## OFFICIAL NOTIFICATION OF DECISION

**Project# PR-2019-002574**  
**Application#**  
**SI-2022-02061 SITE PLAN AMENDMENT**

1. The original project (Site Plan – DRB: PR-2019-002574 / SI-2019-00191) consisted of a 5,021 square foot restaurant with a drive-through. This is a request to amend the site plan to construct a parking lot addition, a modification to the existing drive-through to add a second drive-through lane, transformer re-location, and a modification of the existing single-lane OMD canopy extension to dual lane.
  1. Pursuant to 6-6(G)(3) Review and Decision Criteria An application for a Site Plan – DRB shall be approved if it meets all of the following criteria:
    - a. 6-6(l)(3)(a) The Site Plan complies with all applicable provisions of this IDO, the DPM, other adopted City regulations, and any conditions specifically applied to development of the property in a prior permit or approval affecting the property.

SHEET TITLE
SITE PLAN

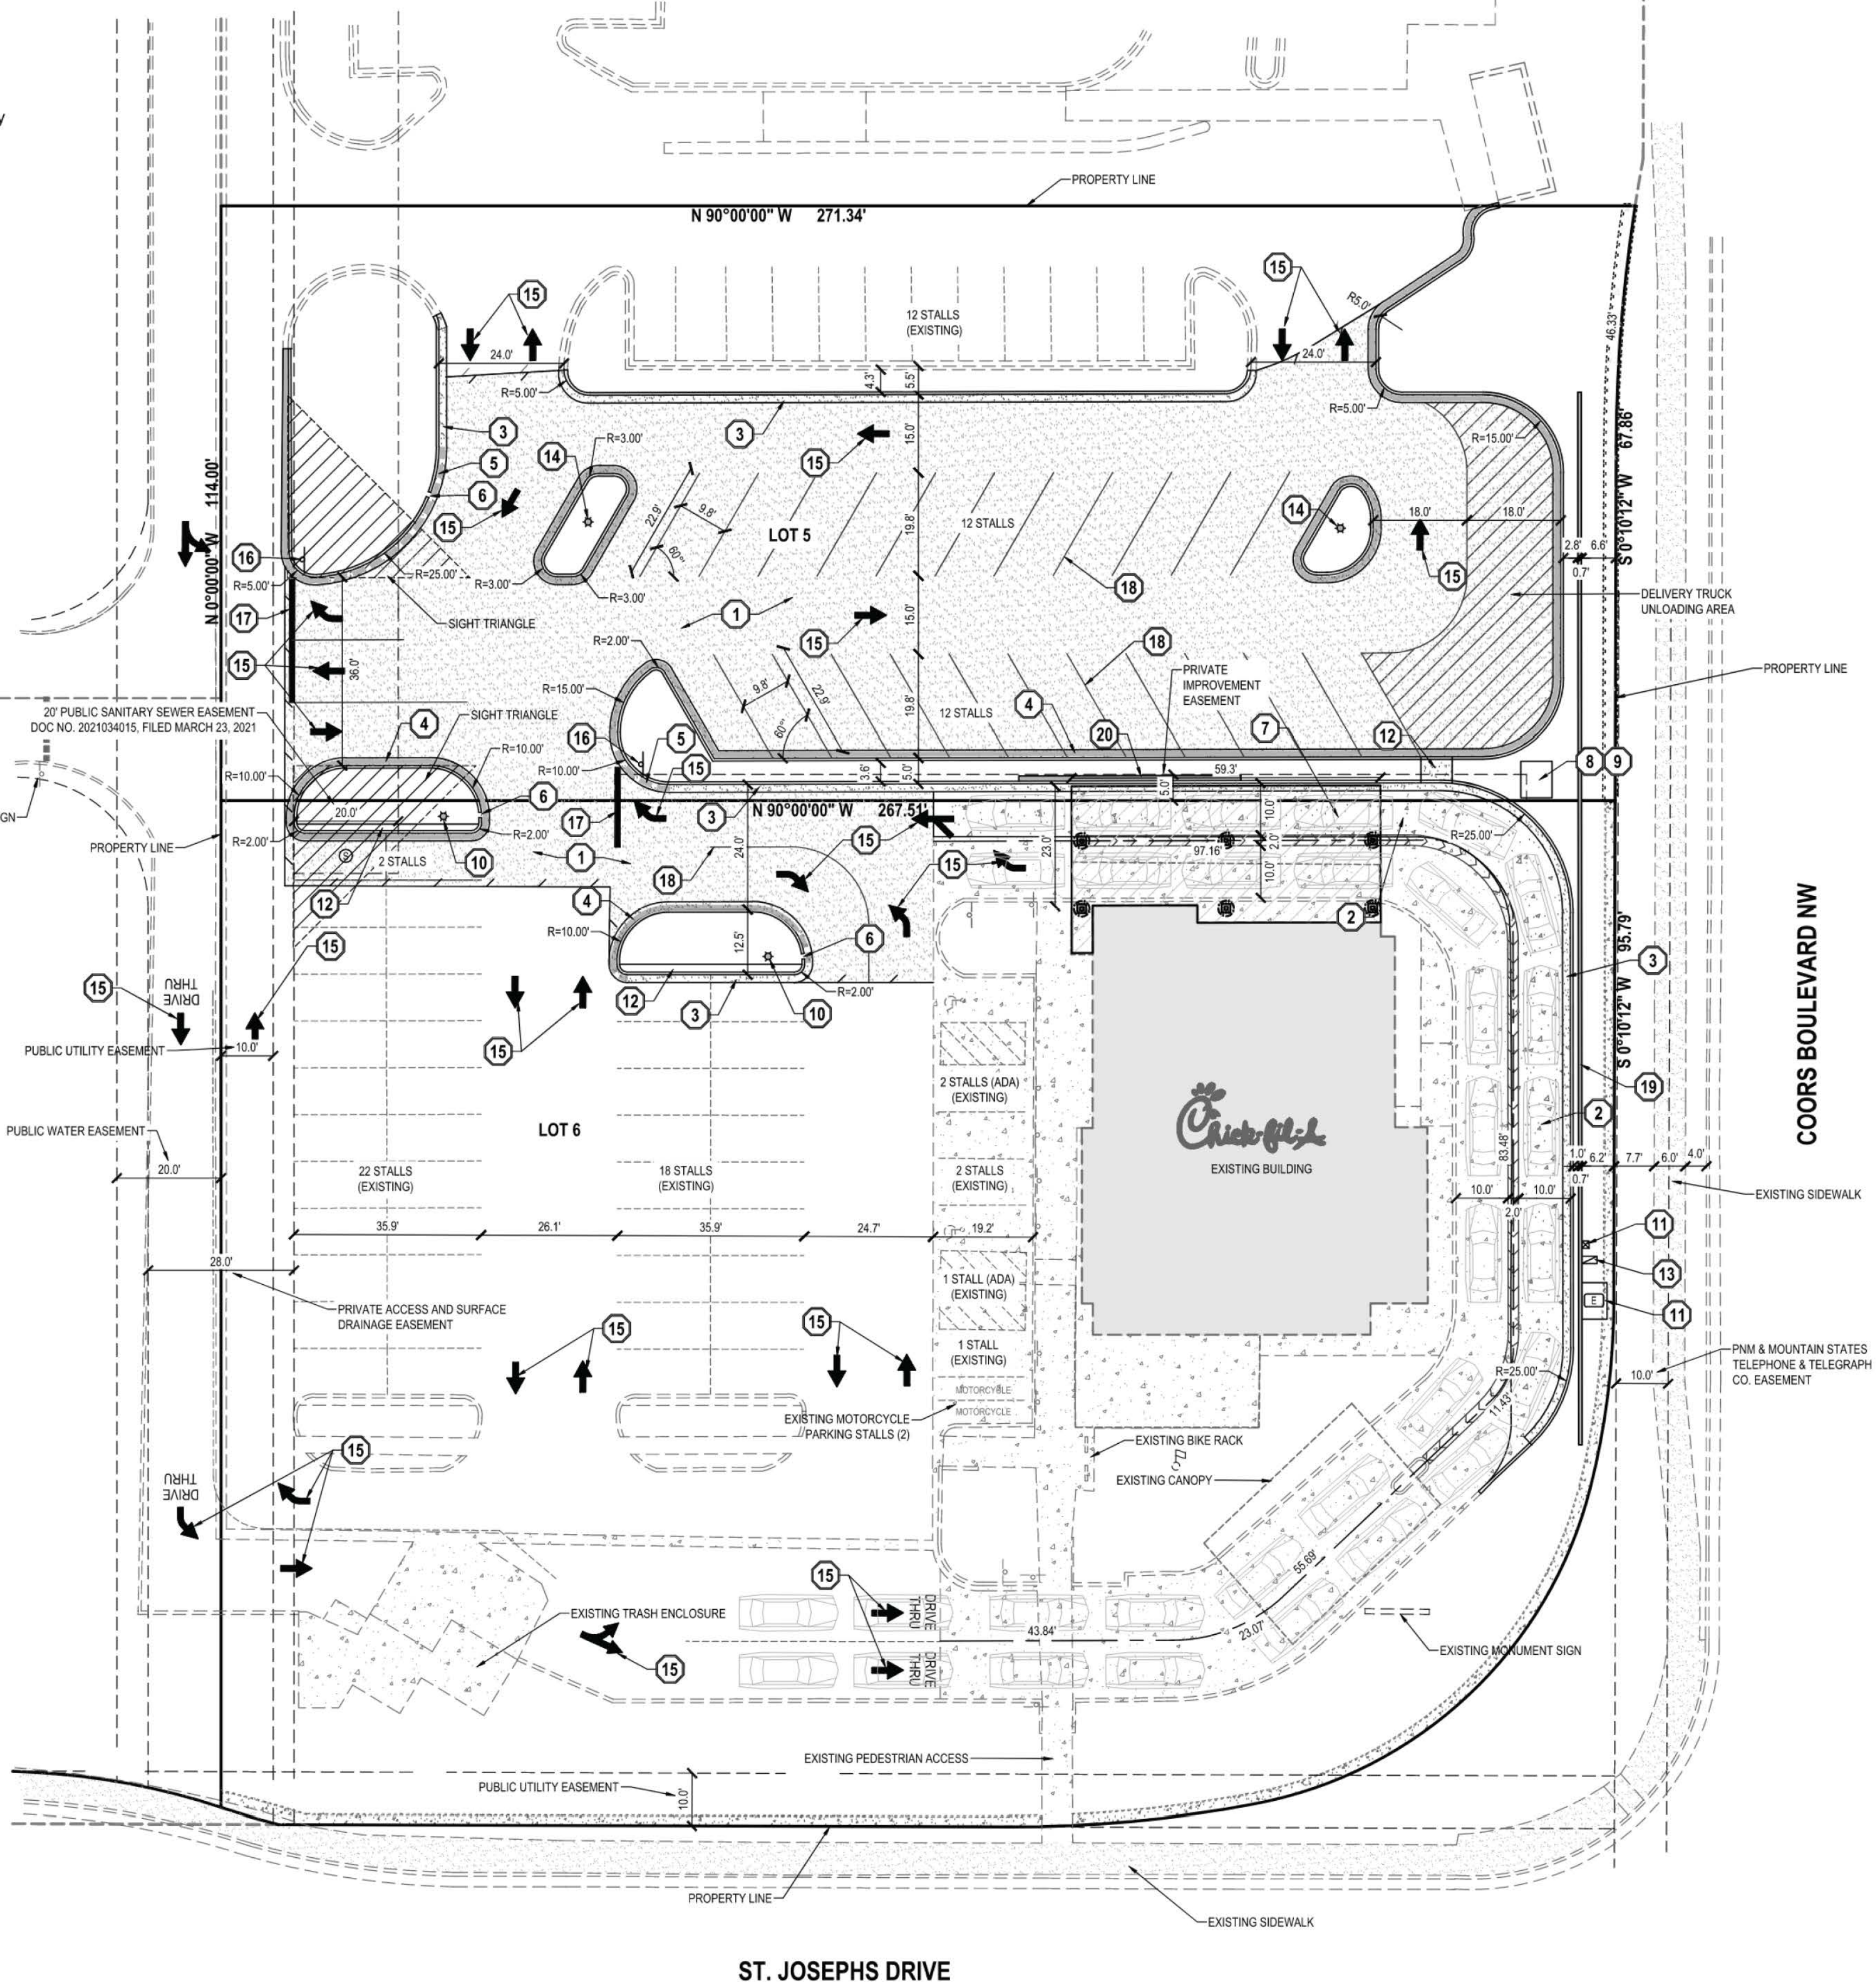
The parking and landscaping comply with the original Site Plan approval and the applicable provisions of the IDO: 4 parking spaces are proposed to be removed, with 26 parking spaces proposed to be added by the parking lot addition, for a total of 73 parking spaces proposed with the amendment where a total of 36 parking spaces are required per the original Site Plan approval. The Landscape Plan depicts landscaping which meets 5-6 (Landscaping, Buffering, and Screening) of the IDO regarding coverage of the net lot area, with landscaping proposed to cover 26% of the net lot area, exceeding the minimum required 15% coverage of the net lot area. The Landscape Plan also meets the landscaping requirements in the setback along Coors Boulevard per the Coors Boulevard Character Protection Overlay zone (CPO-2), 3-4(C)(5)(c) of the IDO, by featuring vegetative coverage/landscaping within the setback between the drive-through and the parking areas and Coors Boulevard as well as a proposed retaining/screening wall between the landscaping and drive-through and parking areas. Conditions of approval for Parks and Recreation and Planning respectively require additional trees east of the wall along Coors Boulevard as well as the correct number of parking lot trees to ensure that 5-6 and 3-4(C)(5)(c) are met.

3. Final sign-off is delegated to Parks and Recreation to add trees along Coors Boulevard east of the proposed retaining/screening wall.
4. Final sign-off is delegated to Planning for the correct number of parking lot trees; to provide a Landscape Plan which shall bring the original Landscape Plan forward with modifications per the Site Plan Amendment; to replace all unhealthy plants with new plants; confirm compliance with the Coors Pavilion Site Plan for Subdivision and the addition of an associated note on the Site Plan Amendment; to confirm that the light poles meet the requirements of 3-4(C)(5)(D) of the IDO; and for the project and application numbers to be added to the Site Plan Amendment.

PLANTING PLAN

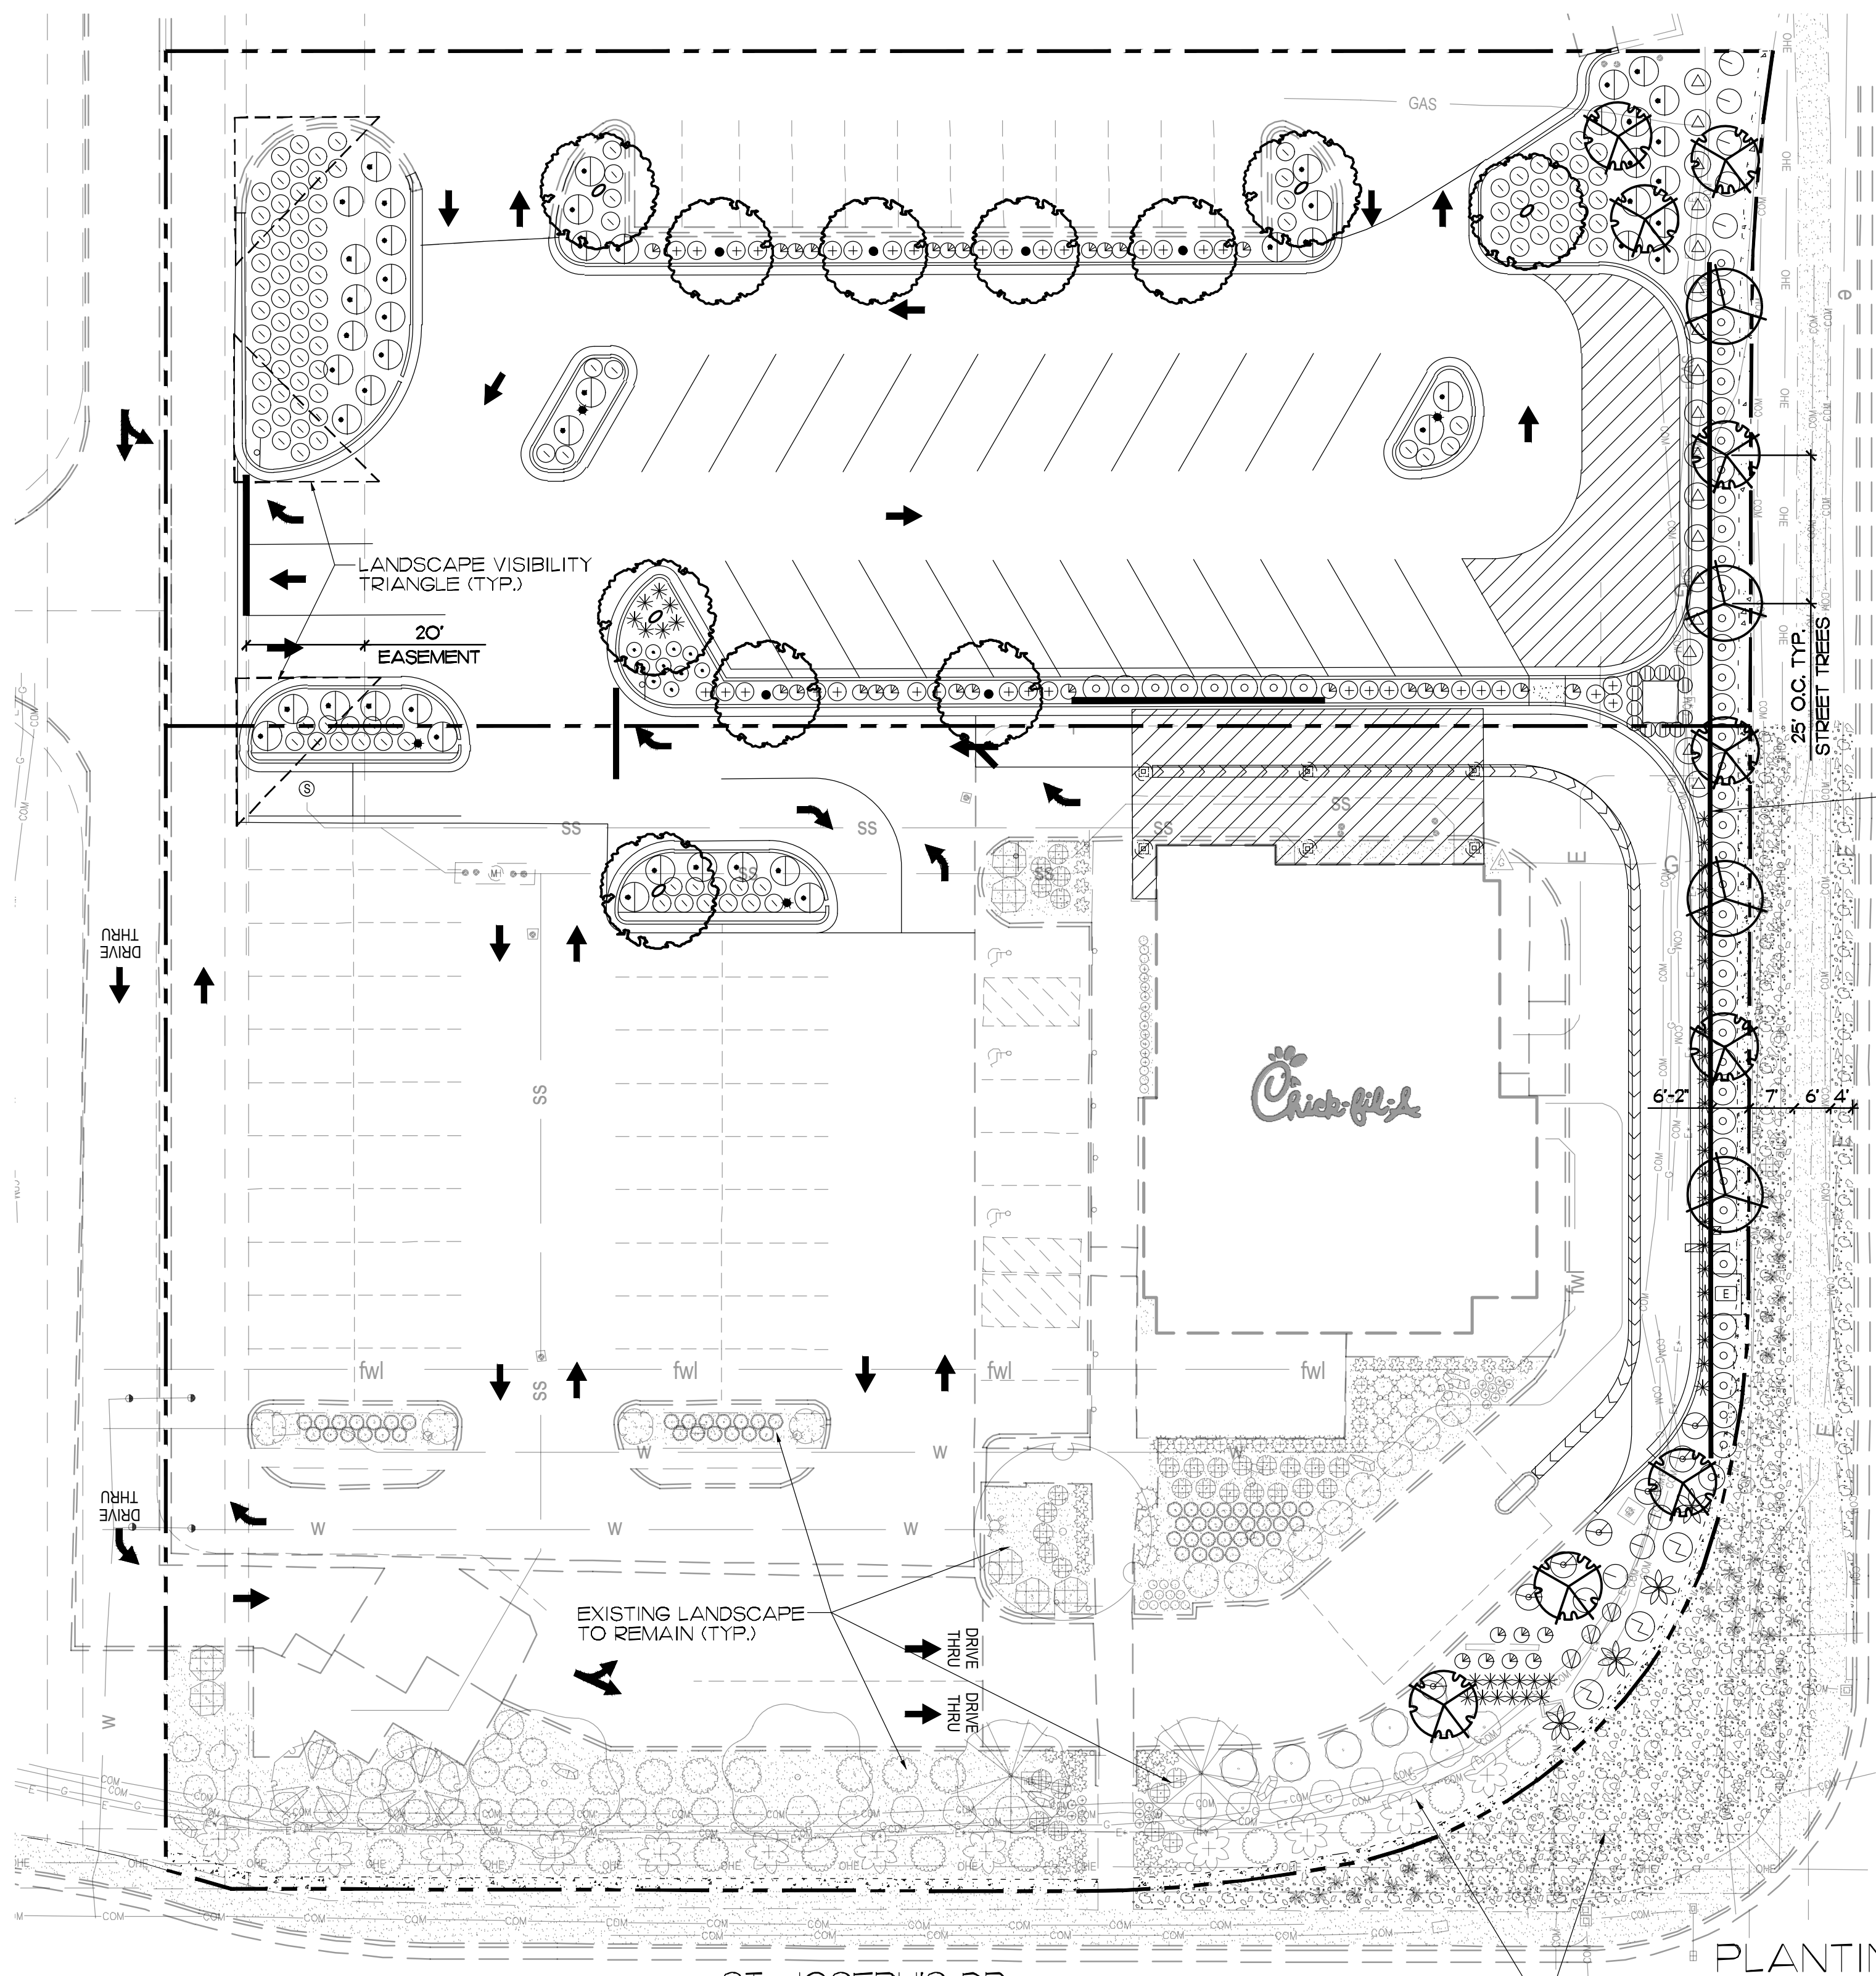
1. This Site Plan Amendment is valid 7 years from DRB approval (11/30/2022). An extension may be requested prior to the expiration date.
2. Final sign-off is delegated to ABCWUA to ensure that trees are not within the easement as discussed at the November 30, 2022 hearing and are not a species with roots that would cause issues with the public sewer line; for the inclusion of the easement document numbers and clarification of the use of those easements; and to ensure that the 20-foot public sanitary sewer easement supersedes the use of the 10-foot private sanitary sewer easement, due to the change of private to public ownership of the 8-inch sanitary sewer line.
